Our ref: HE551507-MMSJV-LSI-000-CO-UU-0002

Wednesday 08 March 2019

A303 Sparkford to Ilchester Dualling Development Consent Order – Non-Material Change

Drawing Title
**LAND PLANS FOR RE-CONSULTATION
REGULATION 5(2)(i)
SHEET 1 OF 2**

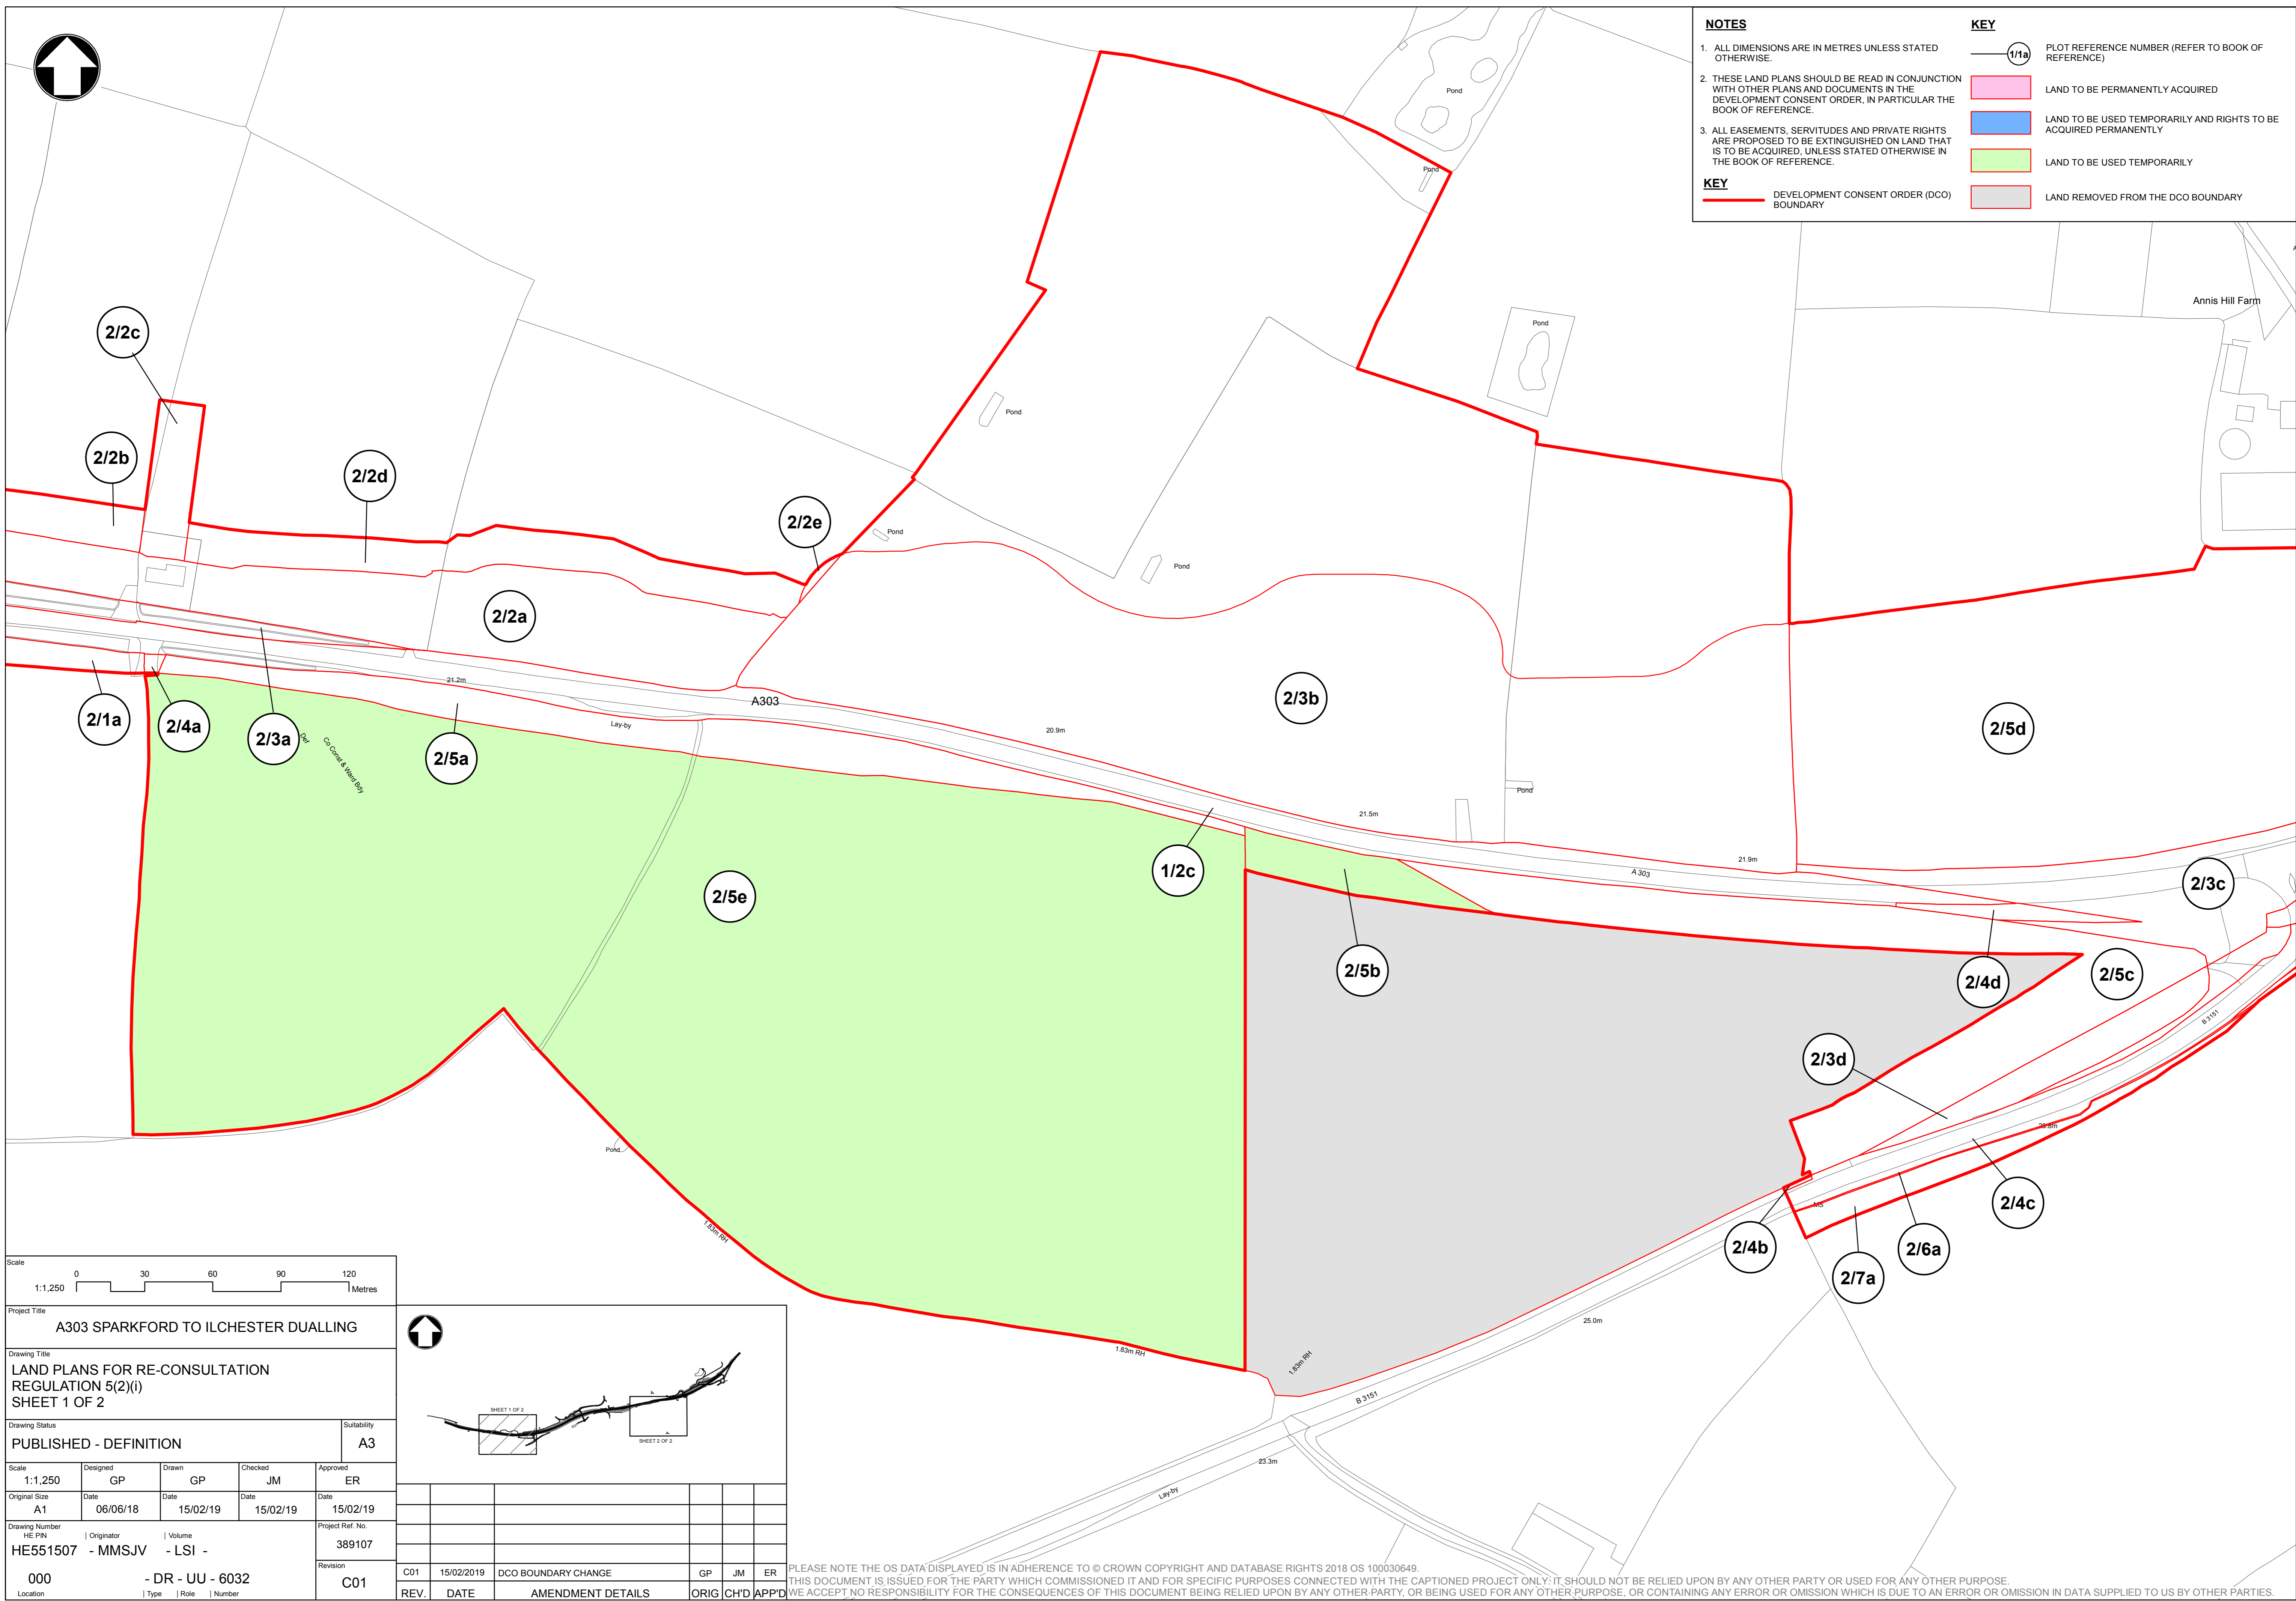
The relevant plots are 1/2b, 1/5a, 4/1f, 4/2a, 4/4b, 5/3j, 7/1c, 7/5a, 7/7d and 7/8c. All of these plots are currently included in the Book of Reference (AS-011) as being subject to permanent acquisition of rights and so the relevant landowners have been notified of the compulsory acquisition proposals and given the opportunity to make representations and/or attend the Compulsory Acquisition hearing of 28 February 2018. The purpose for which the land is required has not changed and so the impact of the physical works on the landowner will be exactly the same, whether rights are acquired or whether the land itself is acquired i.e. the land will be public highway under either scenario.

As a result of the proposed change, it has been necessary to split Plot 4/4b into two plots, as shown on the attached land plans. Originally plot 4/4b was to be subject to temporary possession, with permanent rights being acquired to facilitate statutory undertaker diversions and the dedication of the land as highway, including the ability to transfer maintenance to the County Council. However, to facilitate the construction of a turning head, permanent acquisition is now sought for a small part of this plot and as such, plot 4/4h has been created

by splitting plot 4/4b into two plots. It was not considered to be appropriate or proportionate to change the entire area of plot 4/4b to permanent acquisition.
